Re: 36 Wingate Drive; 183A-C-4; R-3 Residential Zone

**Conditional Use Appeal**

**DECISION**

The applicants, Michael and Susan Russo, pursuant to Section 14-88(a)(2) are seeking a Conditional use to add an accessory dwelling unit within the existing footprint of their single family home.

## PLOT PLAN

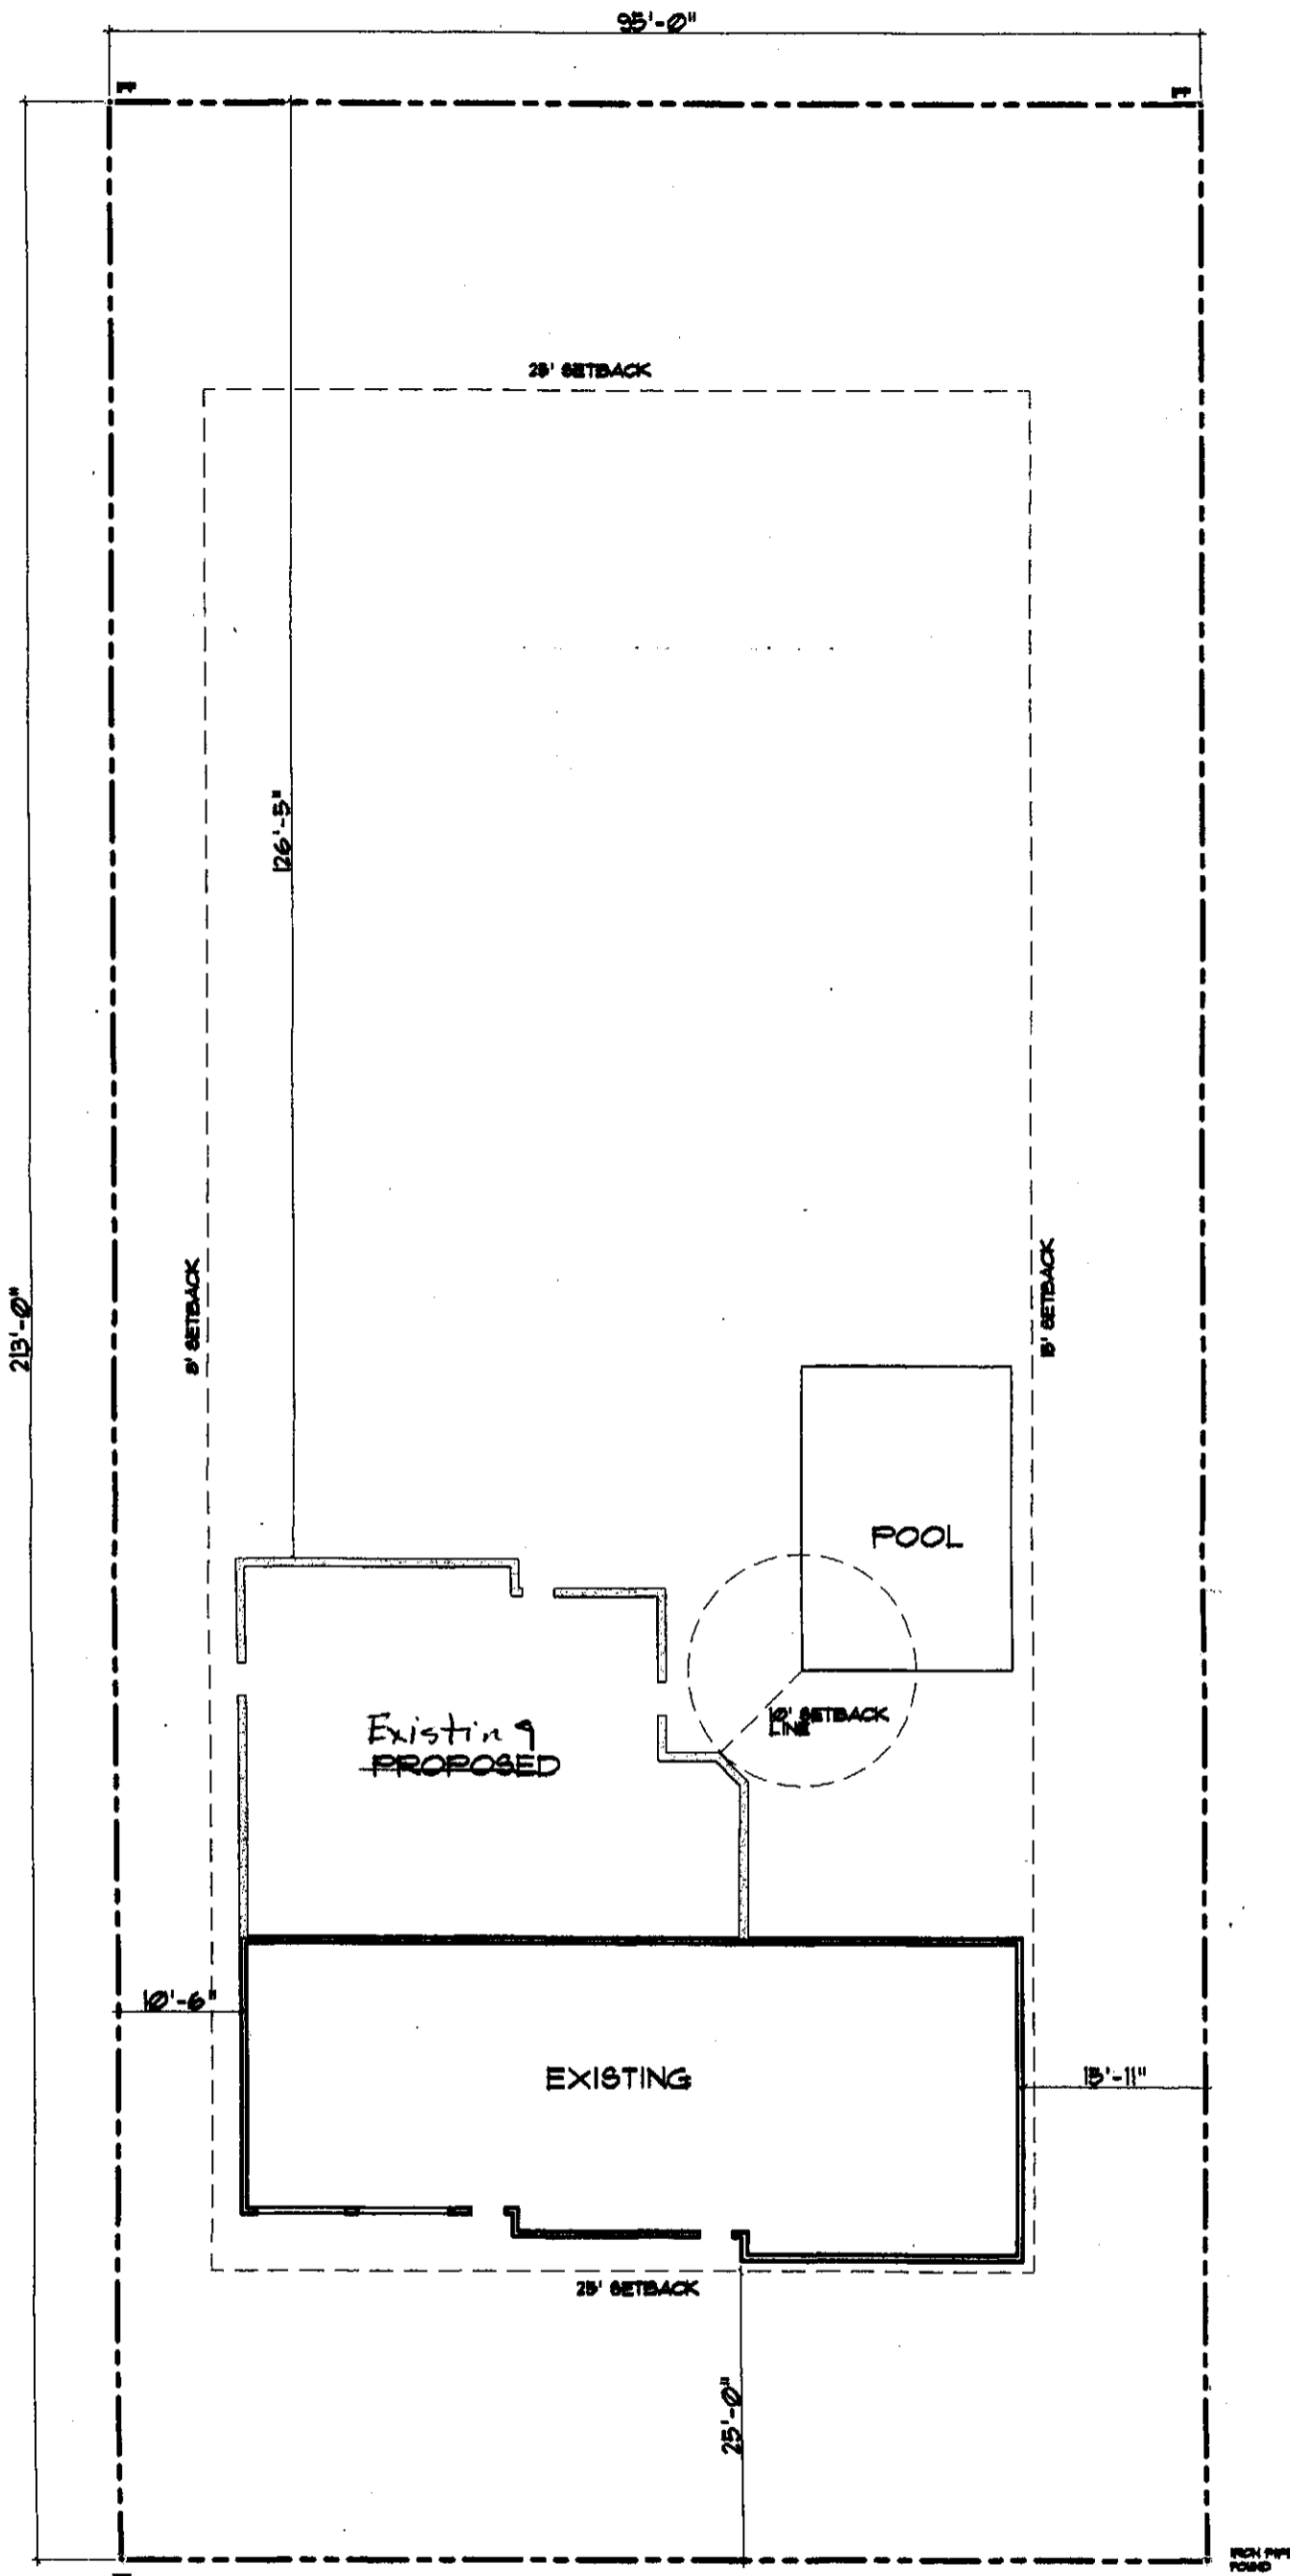
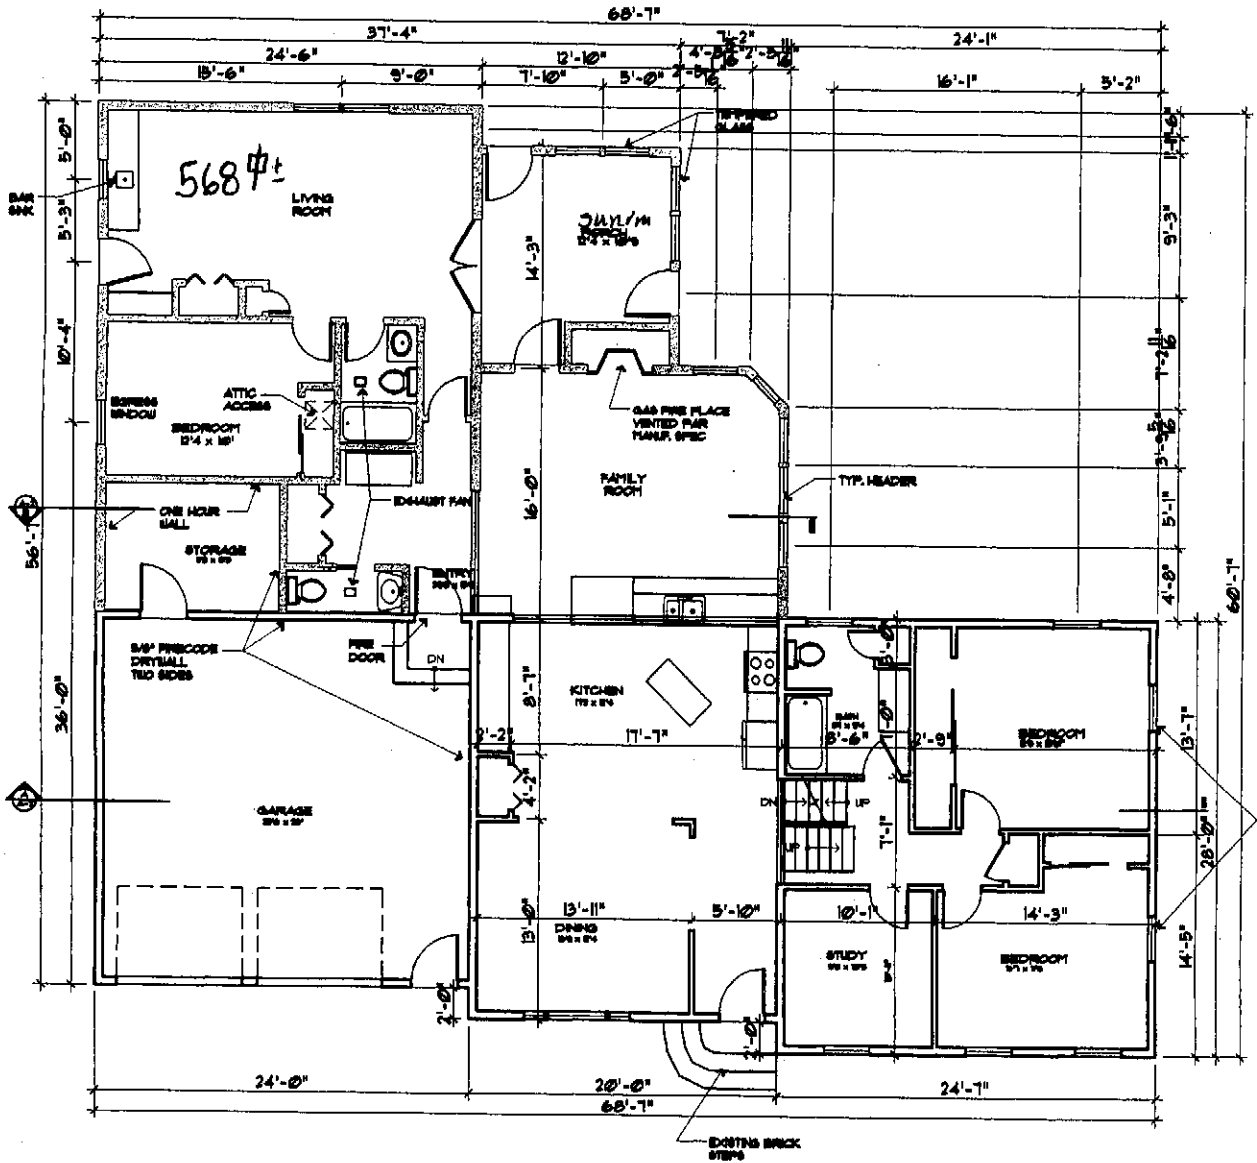
*attached 2 Car garage + 3-5 Spaces in Driveway per site plan + previous application*

# FIRST FLOOR PLAN

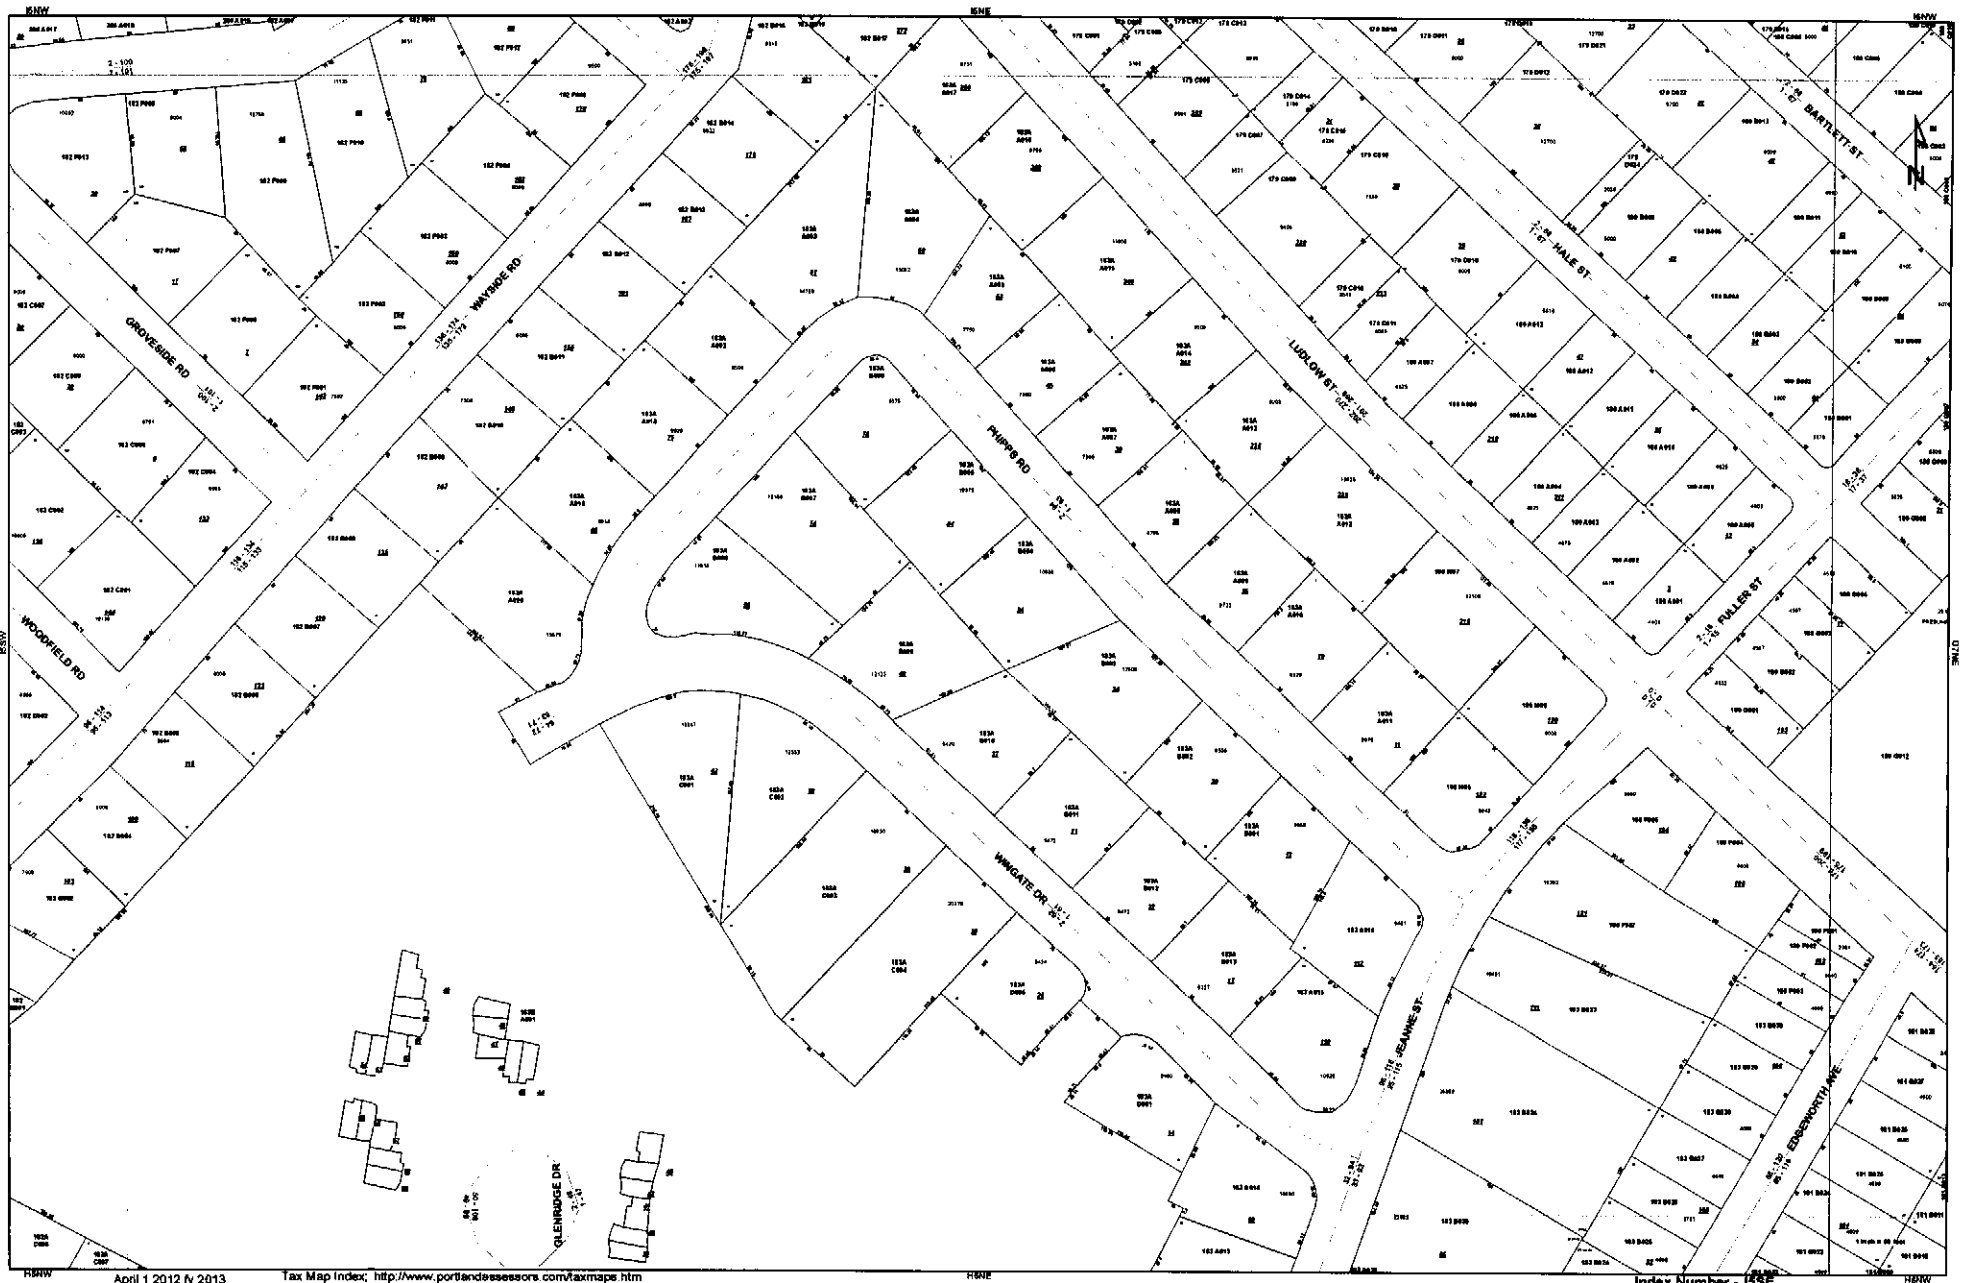
*per application - unit will have 568 sq ft,  
19.6% of gross floor area.  
Floor plan shows as well.*

*per plans & application - no change to  
elevation.  
unit will be on first floor.*
